From: A66 NTP
To: [REDACTED]
Cc: [REDACTED]
Subject: RE: A66 Northern Trans-Pennine Project TR010062
Date: 10 February 2026 09:37:03
Attachments: image001.png
HE615323-JAC-HAW-G3A AL SCHEM-DR-CX-000005.pdf
A66 NTP - UII non-material amendment to the DCO response letter.pdf

Application for a Non-Material Change to The A66 Northern Trans-Pennine Development Consent Order 2024

Application for a Non-Material Change to the A66 Northern Trans-Pennine Development Consent Order 2024 (SI 2024/360), as corrected by the A66 Northern Trans-Pennine Development Consent (Correction) Order 2025 (SI 2025/1084) Request for comments from United Utilities Water Limited

Further to our submission of Friday 16 January, United Utilities Water Limited (U UW) met with the applicant on 2nd February to discuss concerns with the application for a non-material amendment to the above Development Consent Order. These discussions related to Proposed Change 7 which affects the means of access to Penrith Wastewater Treatment Works.

Drawing file: published-documents / TR010062-002559-HE615323-JAC-HAC-03A_AL_SCHEM-DR-CH-201101.pdf

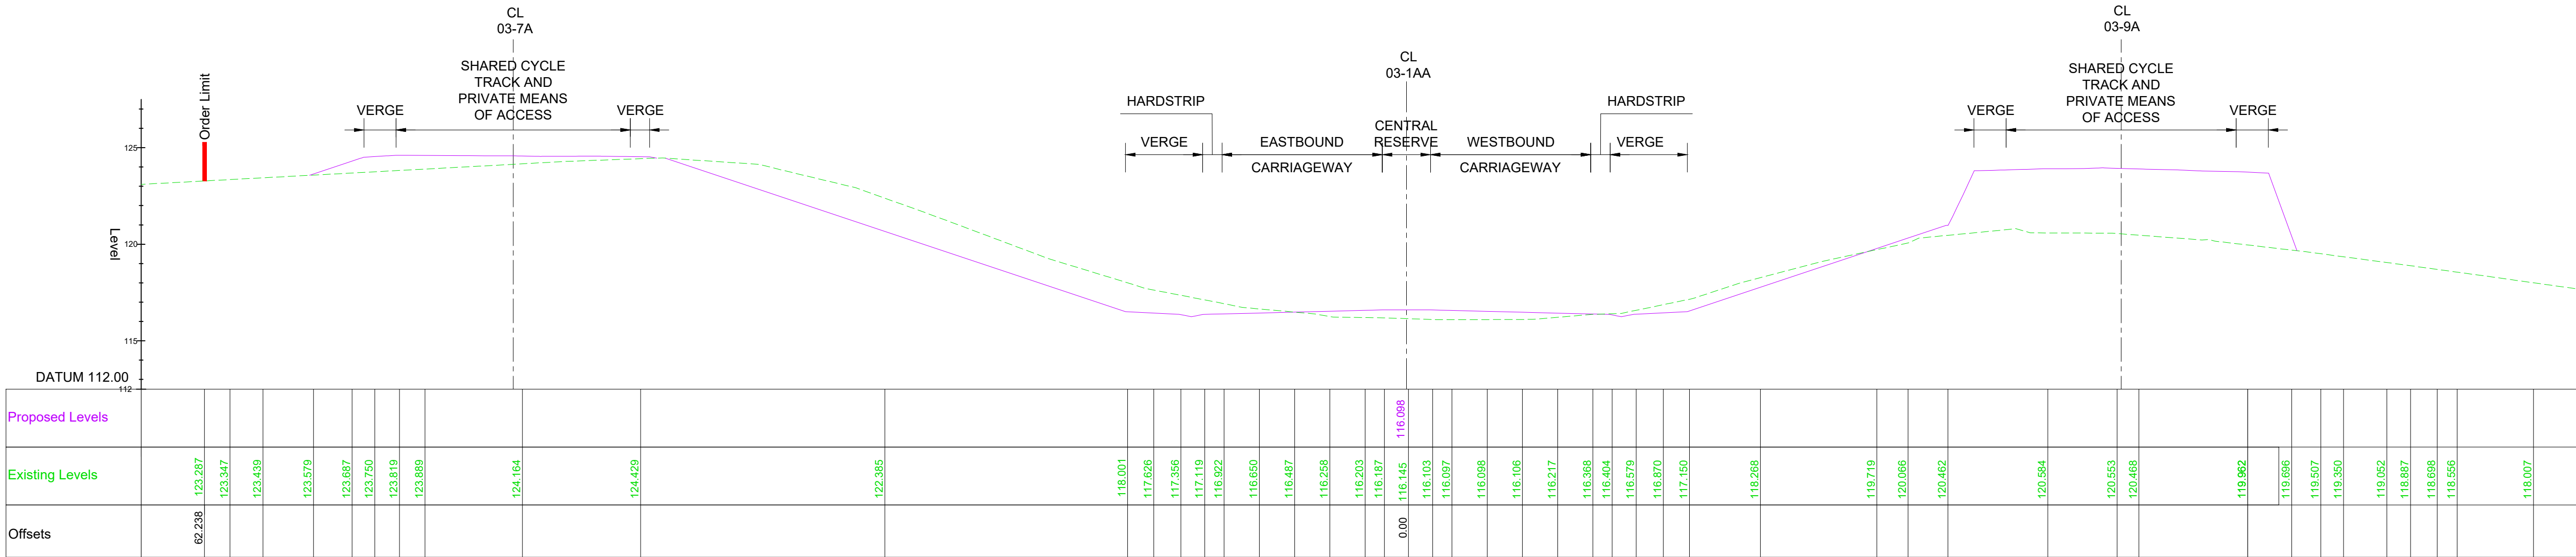
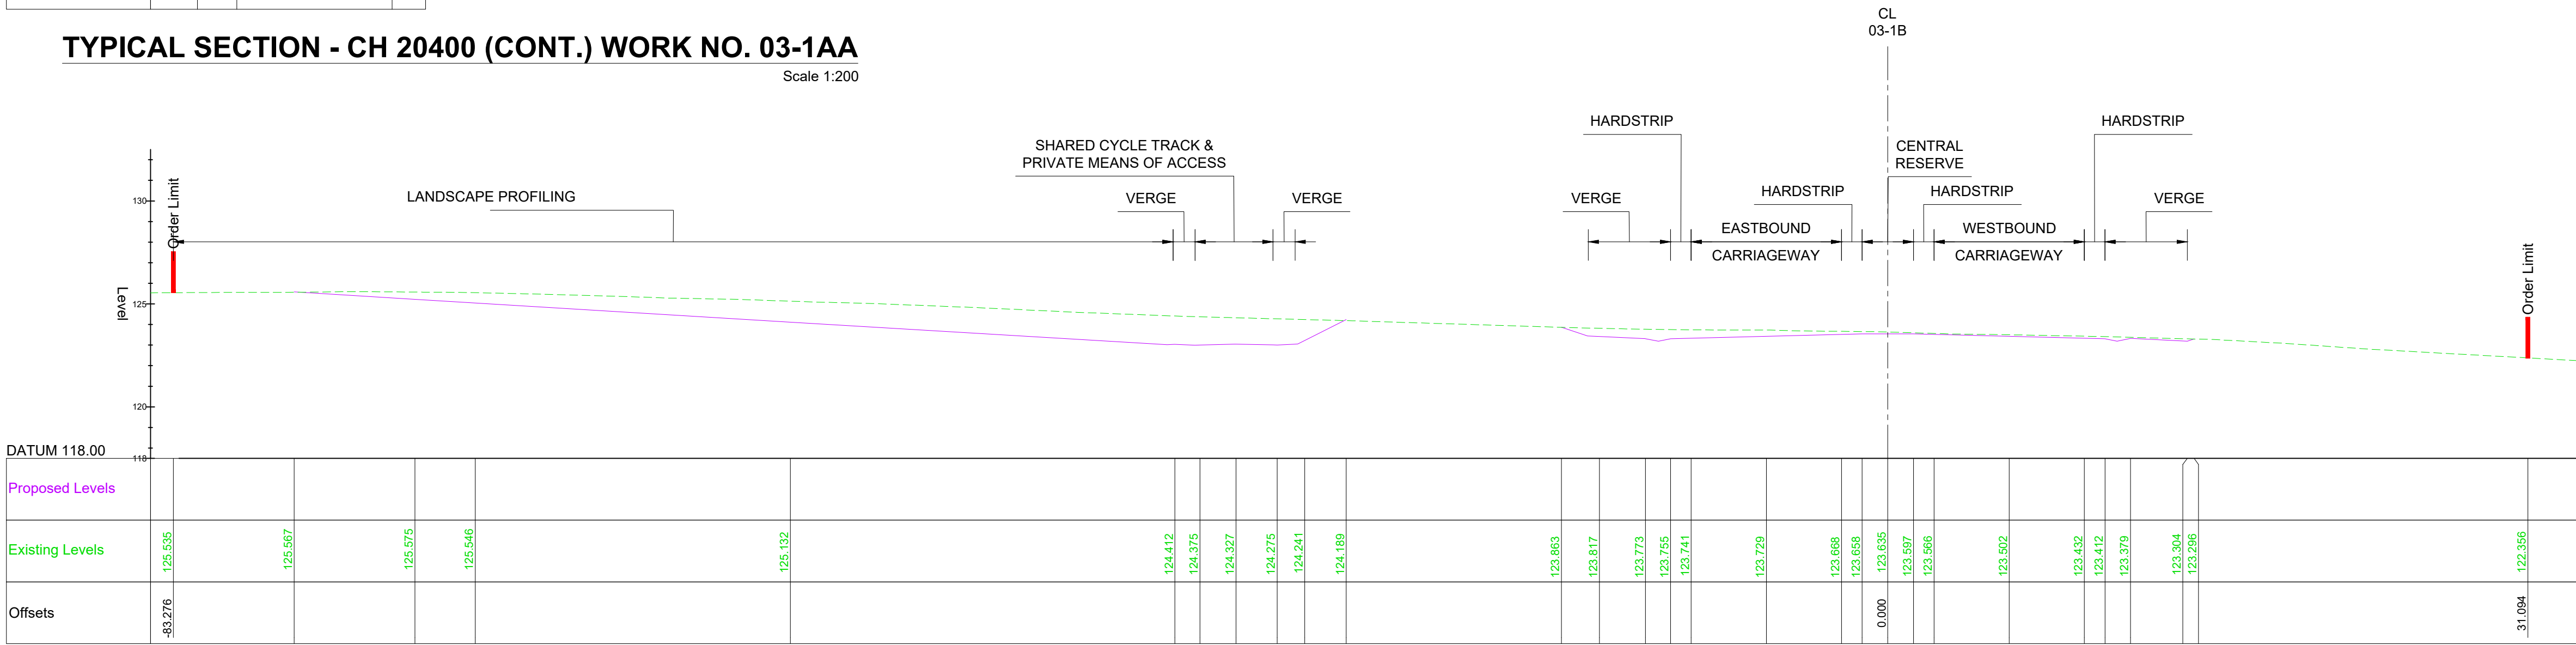
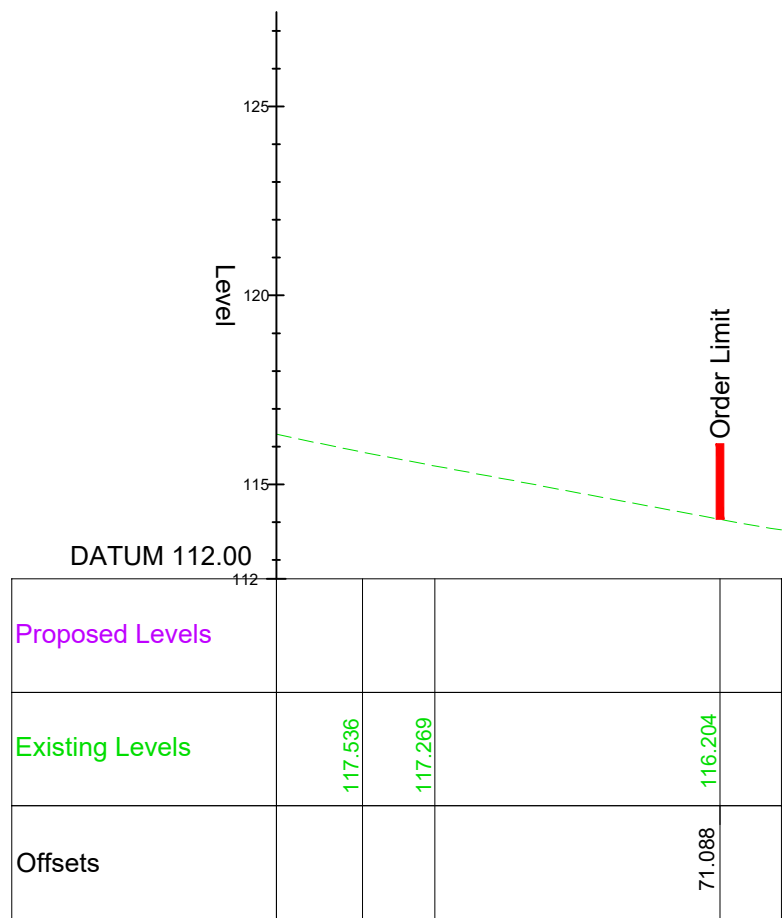
1. separation of the vehicular access from the pedestrian / cycle track; and
2. the location of the previously indicated passing bays for vehicular traffic which would enter and exit the wastewater treatment works.

Point 1 was specifically raised as a result of drawing title '*Engineering Section Drawings (Cross Sections) Regulation 5(2)(o) & 6(2) Sheet 1 of 3*' with drawing number '*HE615323-JAC-HAC-03A_AL_SCHEM DR CH 201101 Rev P03*'. This drawing illustrated a cross section for the access at this point which showed a shared cycle and private means of access without clear separation.

1. an intention to ensure that the pedestrian / cycle track is segregated. This is shown

- indicatively on the attached correspondence and associated plan; and
2. notwithstanding the request of Westmorland and Furness Council to move the location of the passing bays, there remains a requirement to agree the location of the passing bays with both United Utilities Water Limited and Westmorland and Furness Council. At the current time, U UW has concerns at the implications for the change in location of the passing bays which has been suggested by Westmorland and Furness Council, however, we are comfortable at the commitments that have been provided to us by the applicant in the attached correspondence to further discuss and agree this matter reflective of the provisions of the side agreement.
